**Consultation Response from KC Waste Strategy( Refuse & Recycling)**
**2021/94280 land at, Lady Ann Road, Soothill, Batley, WF17 0PY**
**Erection of 65 dwellings with associated works**
**Date Responded: 11/1/2023**
**Responding Officer: Mike Hibbert**
**Responding Ref: WPN22-73**
**NOTES/COMMENTS:**

PROPOSED SITE PLAN

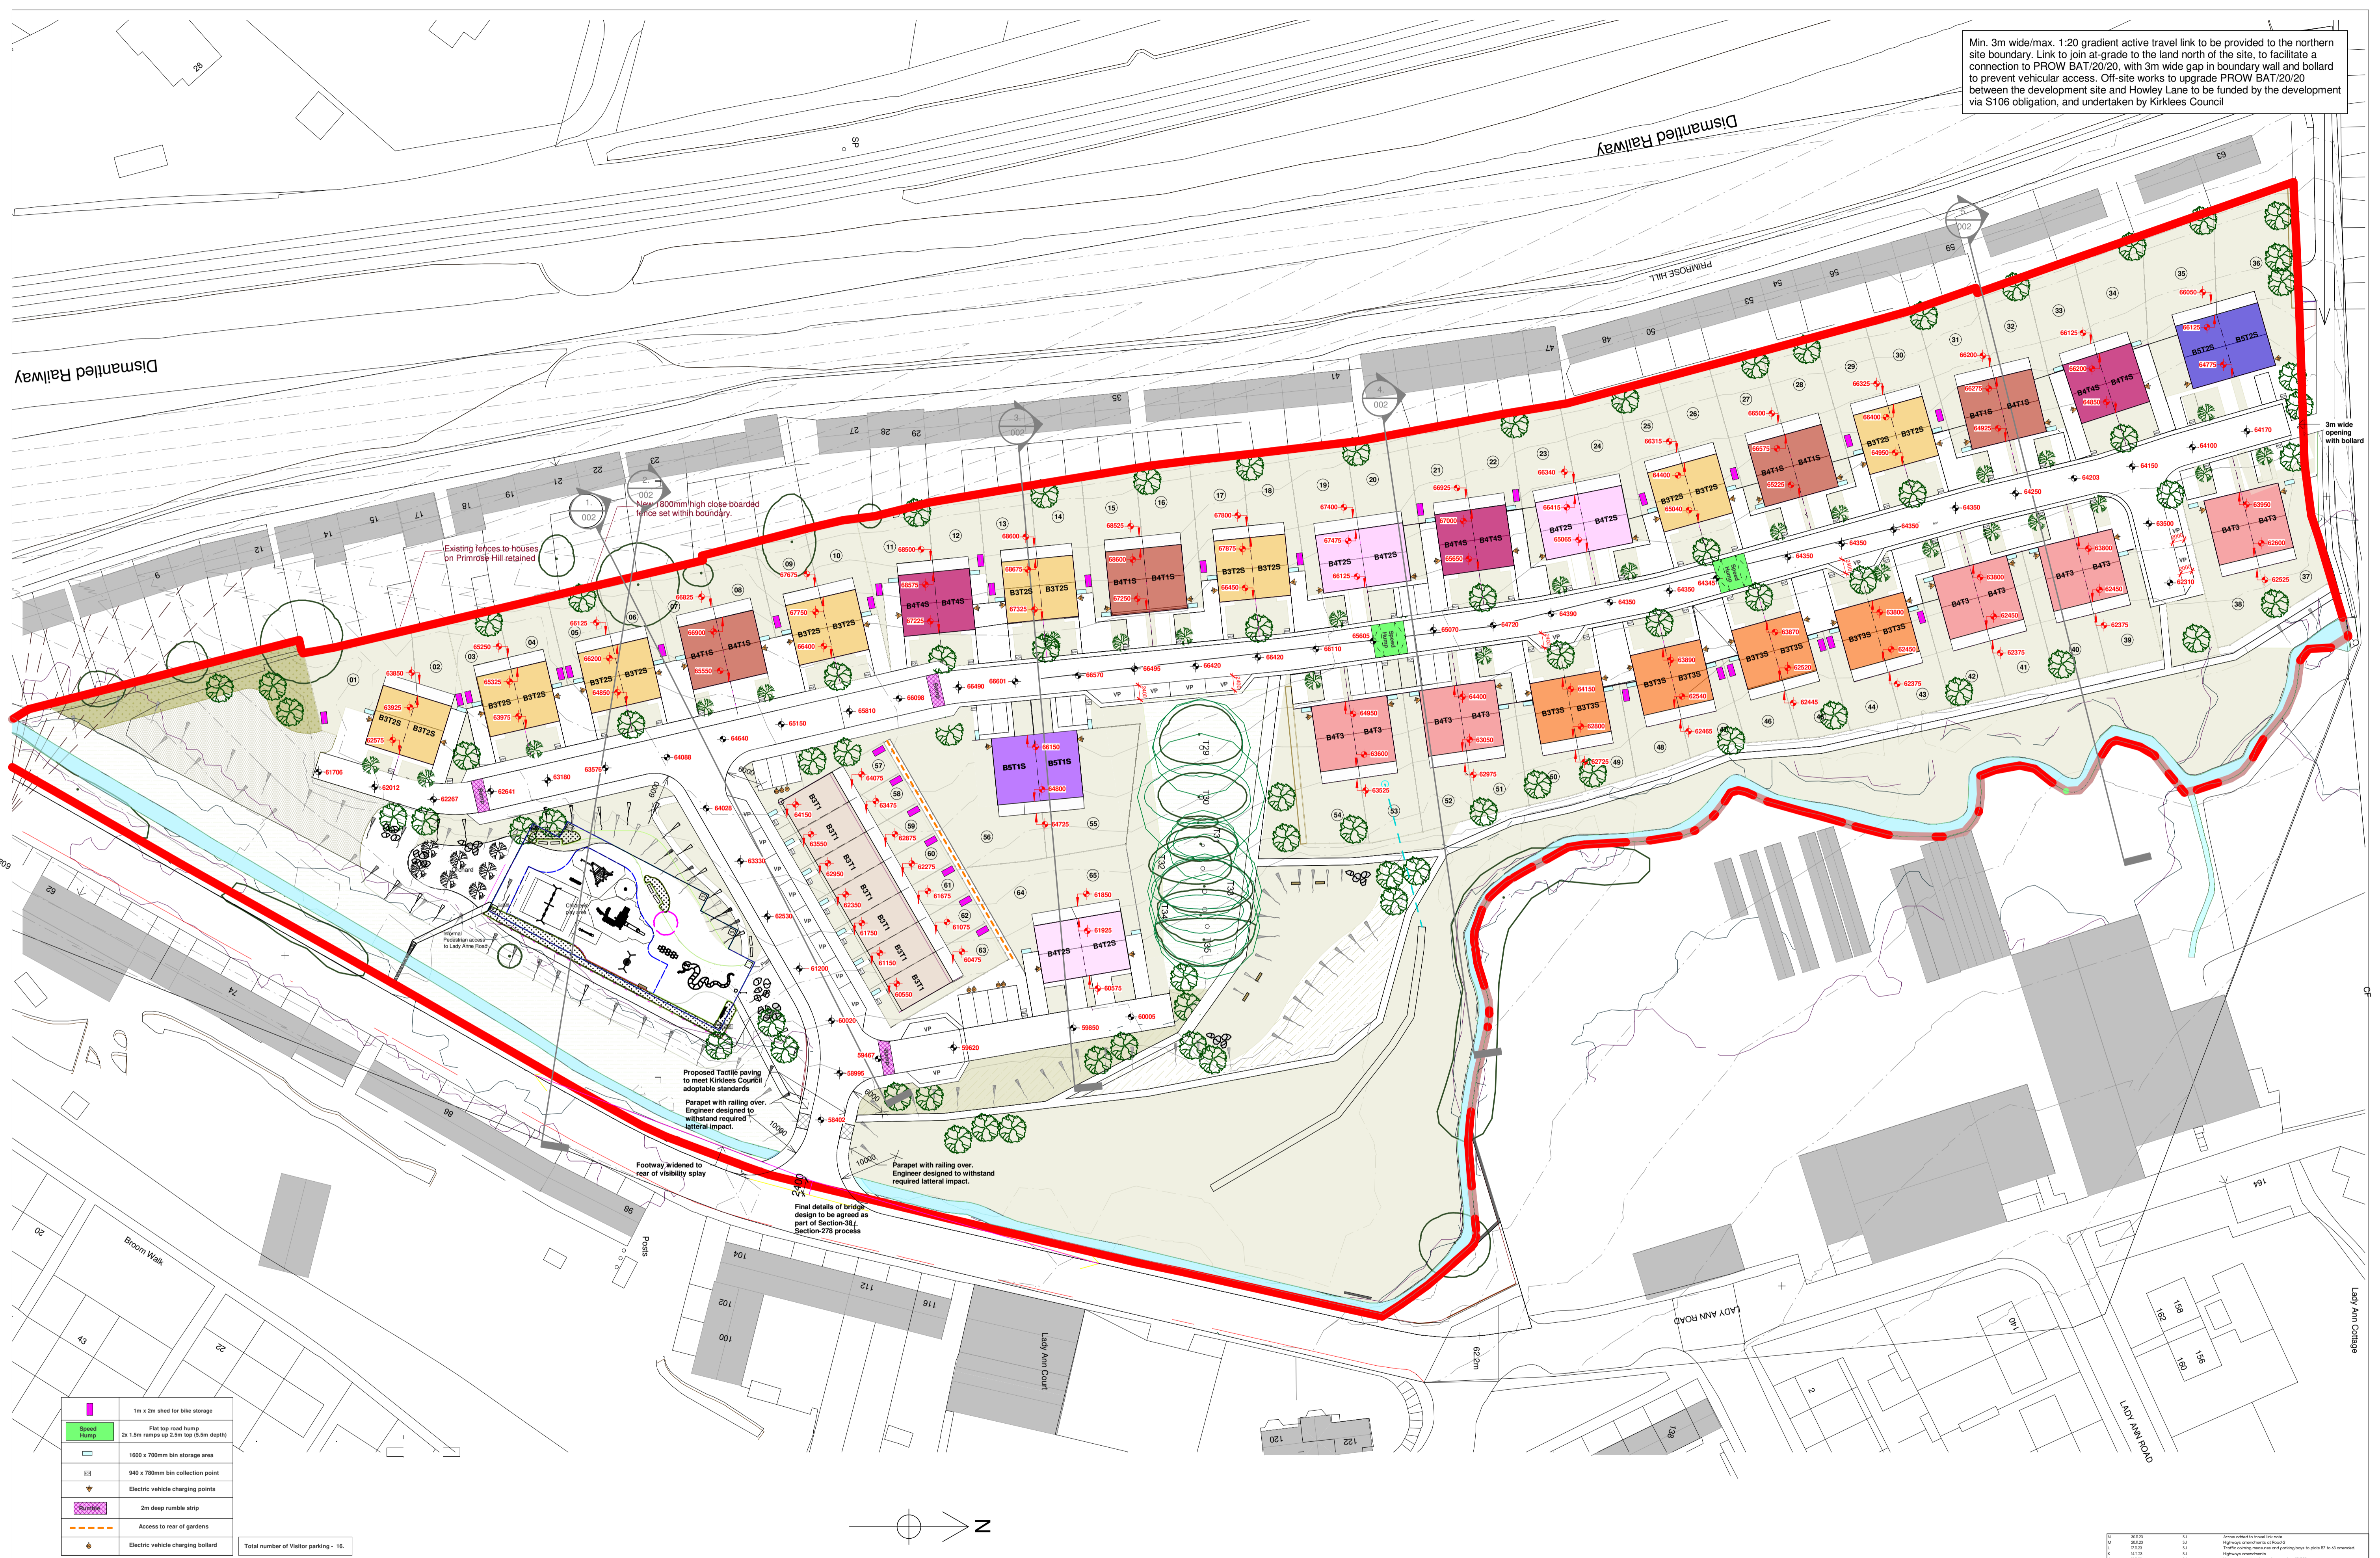
The site plan Dwg 10703-SELF-P-ZZ-A-M3-01 Rev B Dated 12/12/22 is annotated with light blue rectangles to indicate the location of bin storage for the plots on site. Additional information on waste collection and storage is detailed in Section 7.7 Refuse on page 53 of the Residential Development, Design and Access Statement, Lady Ann Road, Batley, dated 21.12.22. This states *“The small sections of private road in front of plots 1-4 and 64-65, allow a refuse vehicle to reverse up to the start of them. Bin stores for plots 1-2 and 64-65 will be located close by. The majority of the houses are provided with a timber bin store located at the back of the parking space and to the side of the house. The bin store is to be 1600 x 700mm, to accommodate 3Nr 80L bins. House types B4T2 and B5T2 have bin stores integrated into their recessed porches, with timber panels and doors. The terraced houses B3T1 have their timber bin stores located to the boundary side of the entrance path in the front garden.”*

- Plan 10703-SELF-P-XX-DR-A-002 dated October 2021 showed a Bin Collection Point (BCP) at the start of the private drive to Plots 1&2. This location appears to have been omitted from the latest plan. The drag out distance from the Plot 1 to this BCP would at approximately 35m is more than the 25m limit in guidance but with Plot 2 being 20m overall the proposal for the BCP at the border of the adopted highway/ private drive is acceptable. BCP's must be large enough for the number of bins to be collected and be on level, hard surfaces such that grouped bins do not cause obstruction to the highway, drives or pedestrian movement on collection day, and so they are accessible for collection.

- Plots 64&65 are located on a private driveway. The proposal for a BCP to service these properties located at the border of the adopted highway/ private drive is acceptable with an indicative drag out distance of 21m.

- The proposed layout of plots 57-63 is a row of terraced properties. On this basis bin storage, avoiding keeping bins under windows/close to doors, will need to be provided at the front of properties. Any such storage would be set within the Streetscene and therefore should be screened and secured to prevent bin blight, the spread of waste into the street, unauthorised use and theft/damage to bins. The potential for having bin storage at the rear of plots 57 and 63 should be explored.

- It is vital that active measures are implemented to prevent parking in the turning head between Plots 38 and 39 at the Northern end of the estate road or preferably the driveways to one or more of the adjacent plots are accessed directly off the turning head. The turning head is not visible when an RCV enters the estate. **If the turning head is blocked by parked vehicles this will necessitate reversing the RCV the length of the estate. This is unacceptable as it is potentially hazardous for both residents and waste collection crews.**
